Rezoning Transportation Analysis

Petition Number: 2020-094

Date	Description
08-12-2020	First Review (KP)
09-21-2020	Second Review (KP)

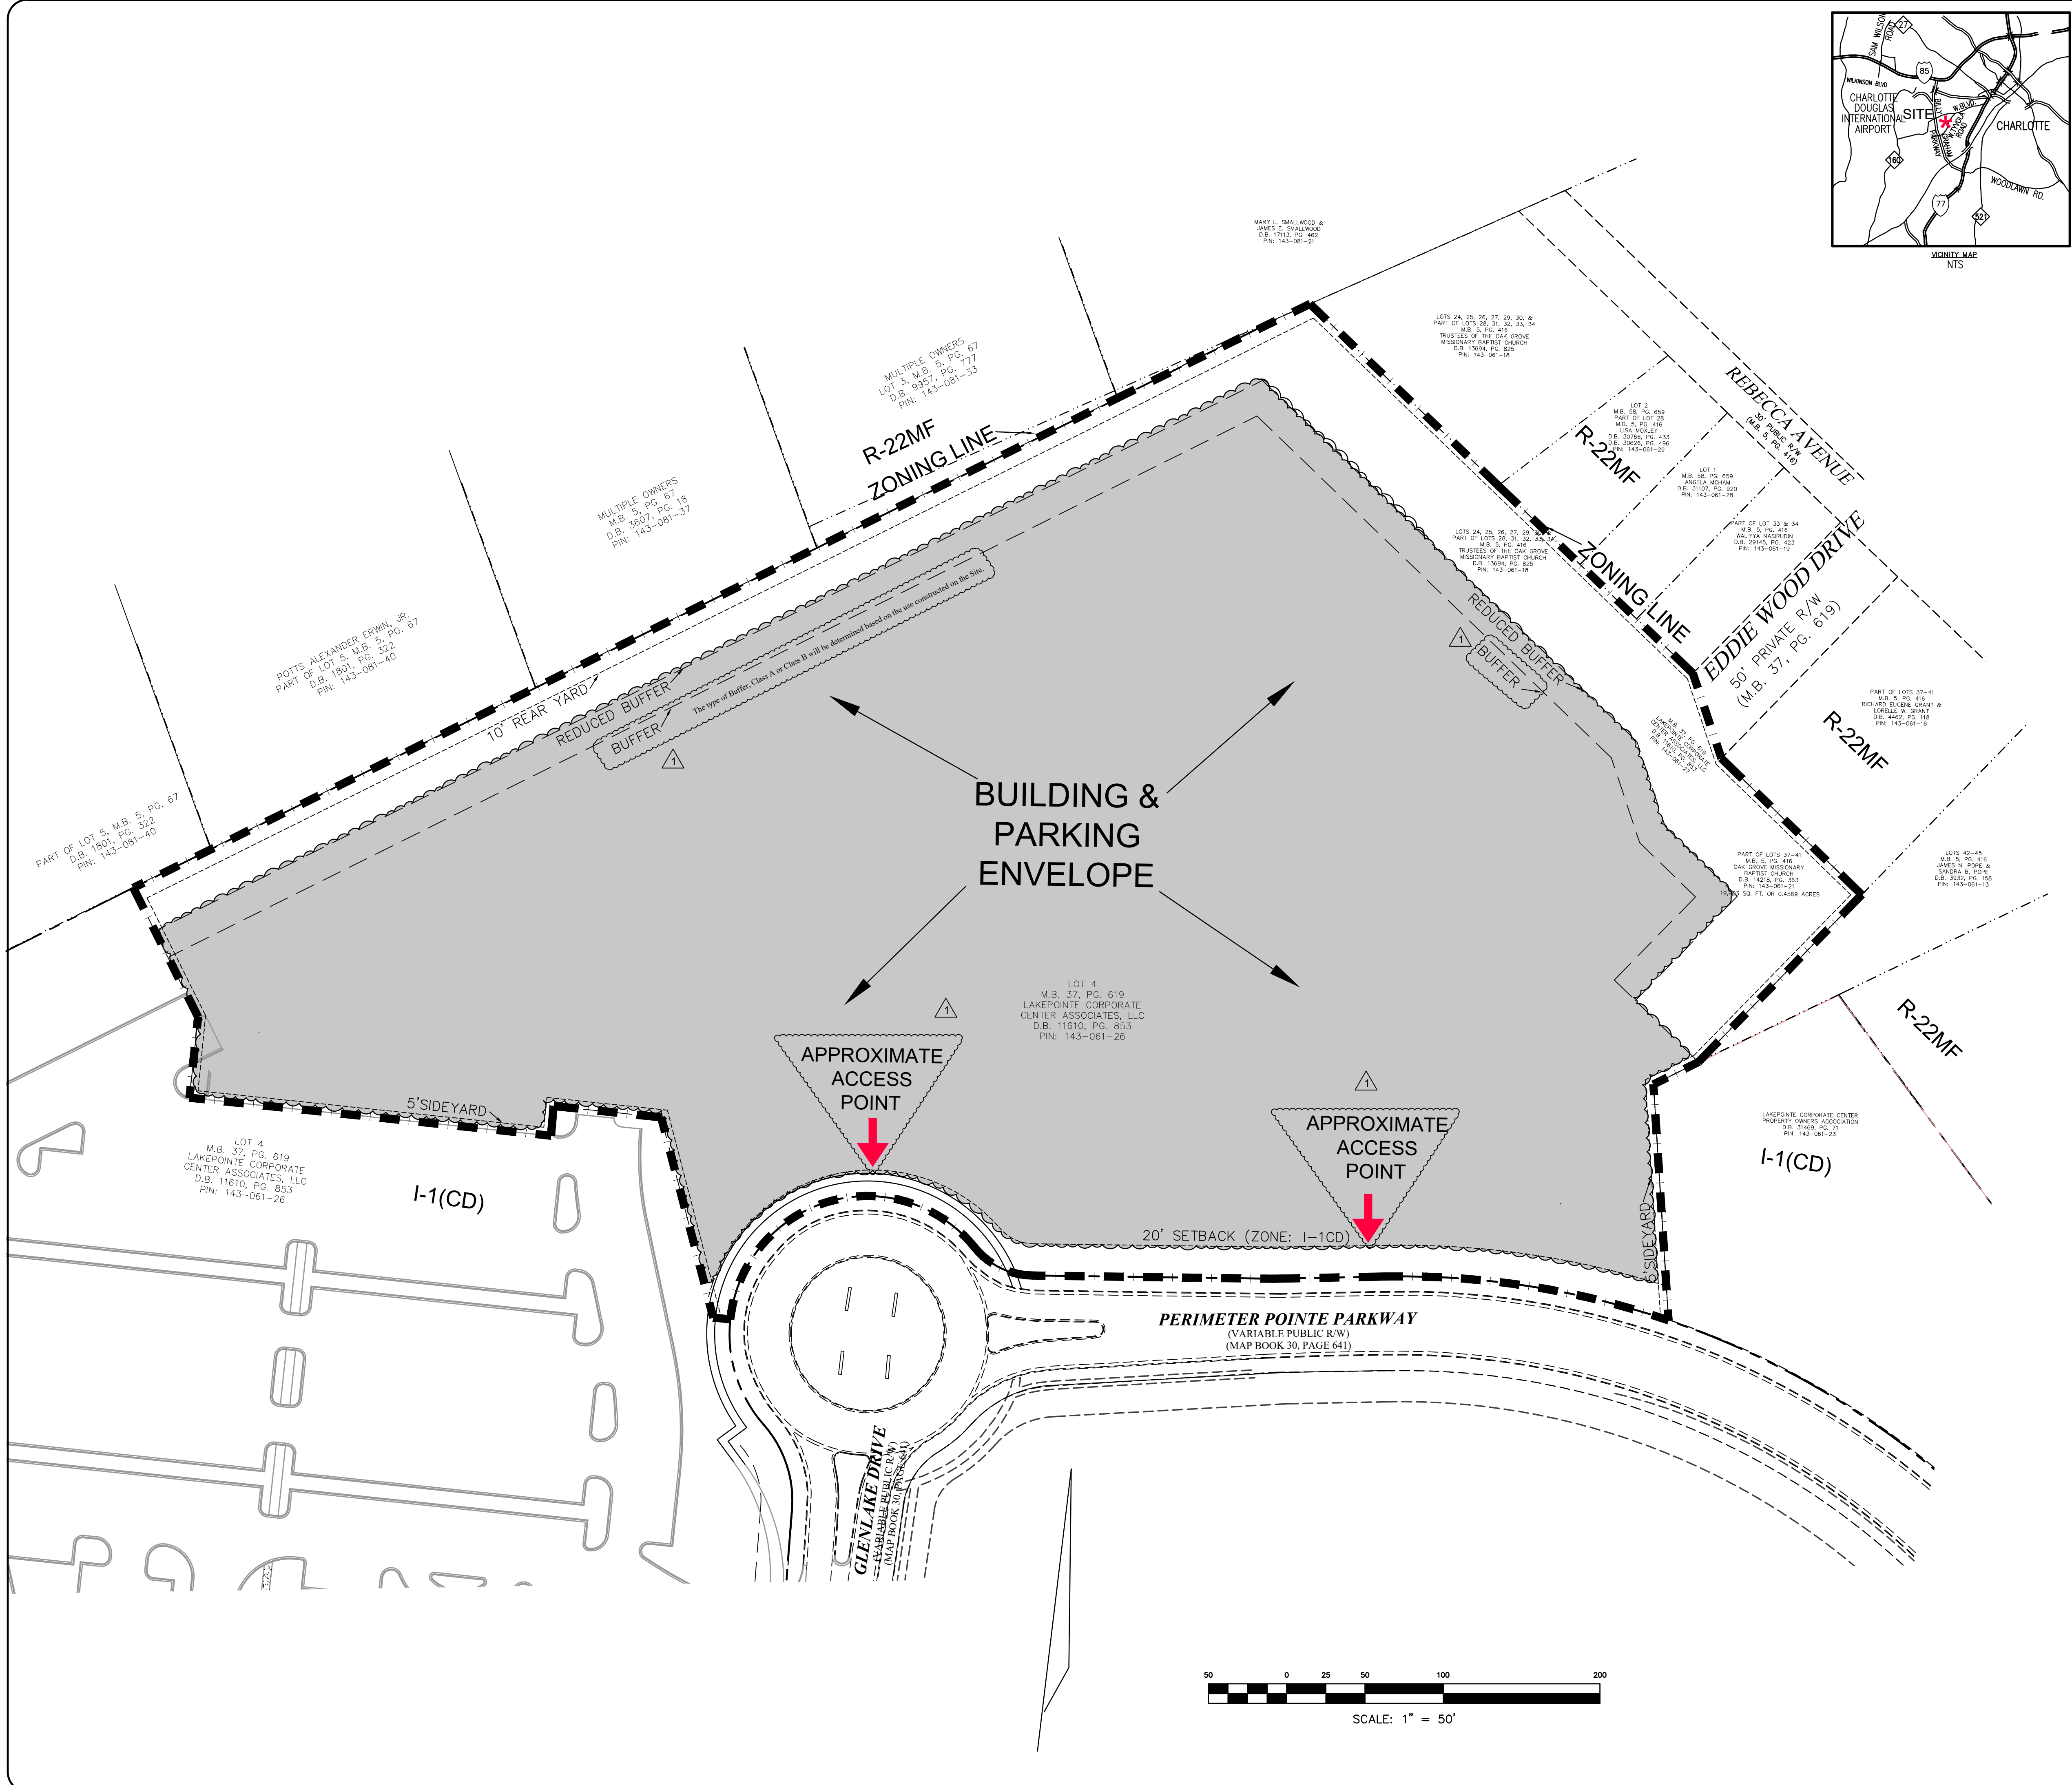
The site is located on a local road. Revise the site plan to address outstanding issues and updated comments related to planting strip, sidewalk, turning movements, and conditional note(s) on requiring transportation improvements being complete before the first building's certificate of occupancy being released.

3. Revise the site plan and conditional note(s) to commit to construct an 8-ft planting strip, and 6-ft sidewalk on Perimeter Pointe Parkway as per Charlotte WALKS. This sidewalk needs to tie into the existing network at the adjacent parcel, 14306125, and extend to the curb ramp at Tyvola Road. Label and dimension both items from the back of curb and gutter and road centerline.

5. Revise the site plan and conditional note(s) to clarify access point(s). The petitioner should have at least one access point that stems off the roundabout, creating the third leg. Turning movements should be performed to ensure the roundabout may function for the petitioner's design vehicles.
Updated to comment: Add a conditional note to clarify these turning movements will be shown during the permitting process.

7. Revise the site plan to add a note specifying all transportation improvements will be approved and constructed before the site's first building certificate of occupancy is issued. The petitioner may phase transportation improvements if said improvements and phasing are explicitly described in site plan notes.
